Winchester City Council Response to Recent Changes to the Order Limits

Ash dieback

21 December 2020.

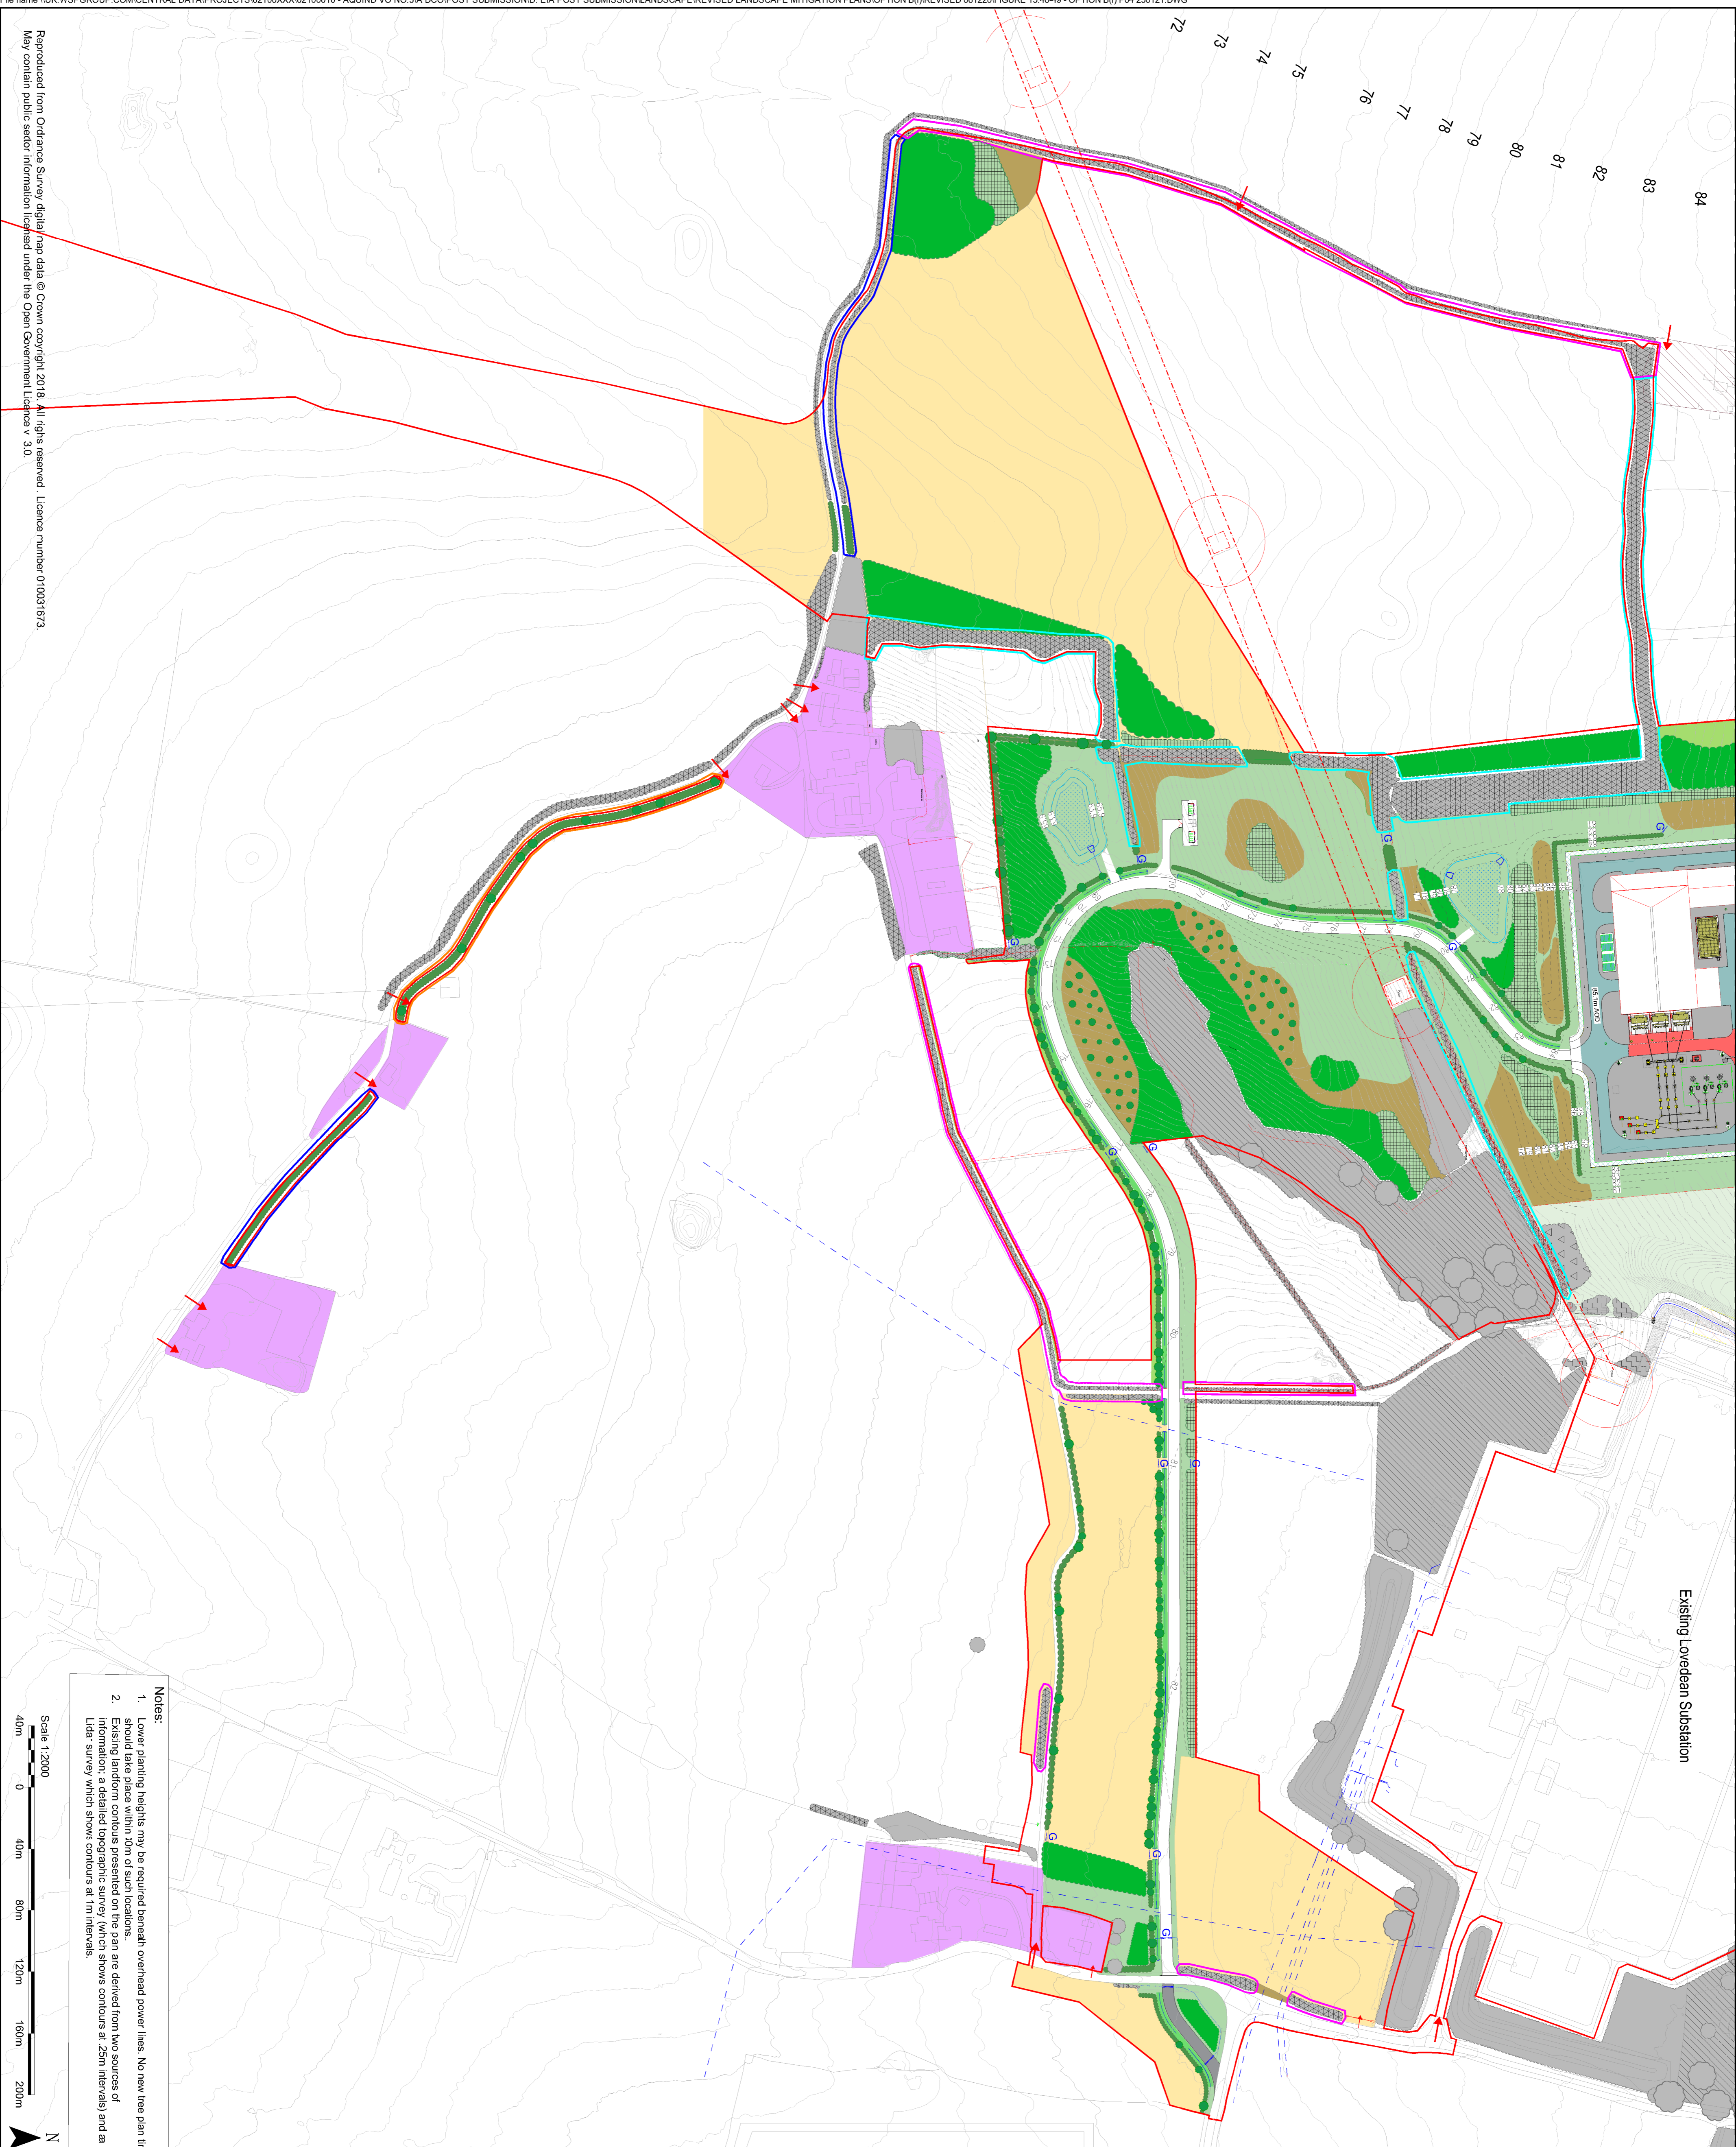
The Council is supportive of this change to the scheme as far as they go. However, it would like some clarification why the assessment does not appear to have considered the potential dieback implications on the existing landscape screening that lies to the west of the site for the proposed converter station. Having considered the Tree Constraints Plans (REP1-101) and the descriptive tables that set out the Tree Survey Schedule Rev 002 (REP3-007) it appears that ash does form an important part of the makeup of some of the landscape features on this side of the site. Attached below is a cut and paste of sheet 6 of 41 from the Tree Constraint Plans. The tree survey schedule records the following examples of ash trees in some of the features recorded on this plan :

G639 Boundary group of large mature ash. Some very large specimens at southern end.

G689 is mature ash and oak overstorey.....

G705 Group of mature large ash and oak.....

H879 Large ash standards to 15m.....

The assessment undertaken does not appear to give any weight to the implication of ash loss to features on this side of the development. On the basis that ash dieback has been accepted as potentially reducing the effectiveness of the existing landscape screening, what measures are proposed to consider and address the implications on this side of the proposed development?
